**From:** Sam.Dumbrell@westsussex.gov.uk  
**Sent:** 10 August 2012 17:22  
**To:** Katherine Rawlins  
**Cc:** Graham Evans  
**Subject:** Re: FW: Eastergate C of E Primary School Containerised Biomass Boiler (Ref: EG/43/12/)  
**Importance:** High

**Re. Eastergate Cof E Primary School - proposed containerised biomass boiler**

DOUCH ECO 1 SRINGHILL ORCHARD, WEIRWOOD, FOREST ROW, EAST SUSSEX, RH18 5HT. 01342 825143
DRAWING NUMBER: 0029 010
DRAWN BY: AK
DATE: 04/04/2012
SCALE: 1:50 @ A3
CLIENT: JUDE HOLLAND
ADDRESS: EASTERGATE PRIMARY SCHOOL
TITLE: BOILER SECTION A A
REVISION: 1
NOTES:

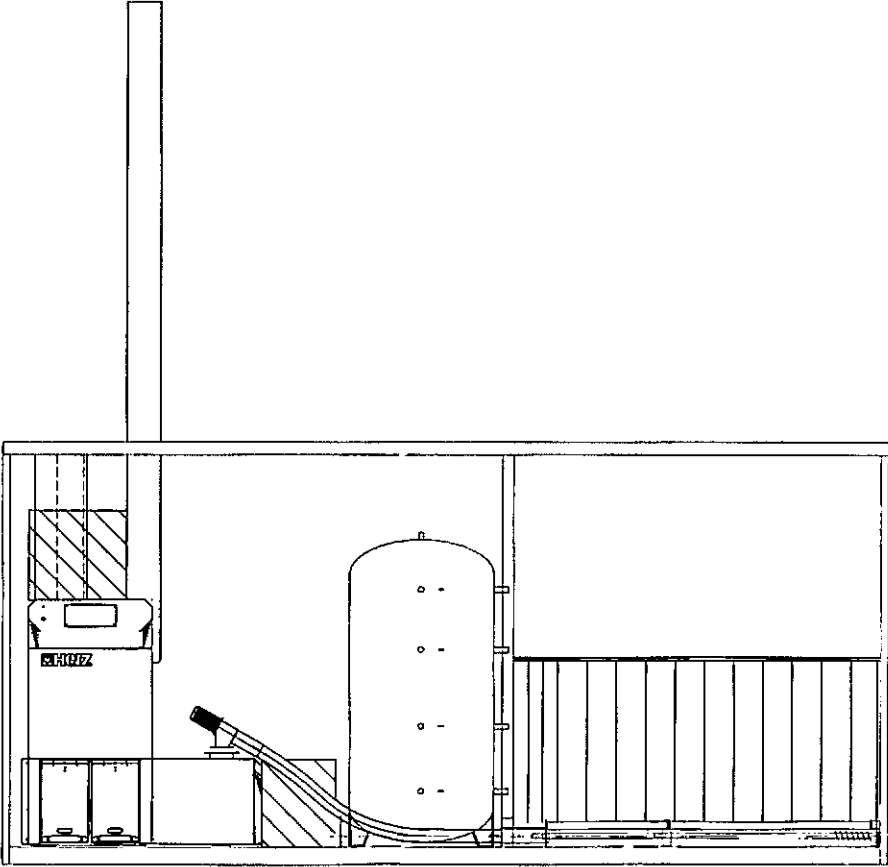
Regarding the EHO's response of 'no objection' following submission of the additional information, I'm concerned that the EHO states that *"Insufficient information is available in the application to enable such an assessment, in particular the height and diameter of the stack. I would again request the completion submission of the attached Biomass Boiler Information Request form if this can be arranged"*. Is this information mandatory or desirable? Can it or should it be conditioned? I've asked the agent to comment also. He says that he has not yet seen this Request form yet?

That said, I measure the chimney heights to be 2.9m from the top of the container (container being 2.8m high) and 4.35m in total from the Boiler Section A-A plan.

Local Air Quality Management Technical Guidance TG(09) requires that plant burning biomass in 50kW to 20MW units are identified and that a screening assessment is undertaken for the purposes of Local Air Quality Management. Insufficient information is available in the application to enable such an assessment, in particular the height and diameter of the stack. I would again request the completion submission of the attached Biomass Boiler Information Request form if this can be arranged.

Maximum boiler output: 80kW

Maximum output in 1 hr: 80 kWh

Energy content of wood pellets @ 10% moisture content 4732 kWh/t

Fuel consumption at maximum output in 1 hour:  $80/4732 = 0.0169$  t or 16.9kg, well under the limit that requires a chimney height approval from Arun DC.
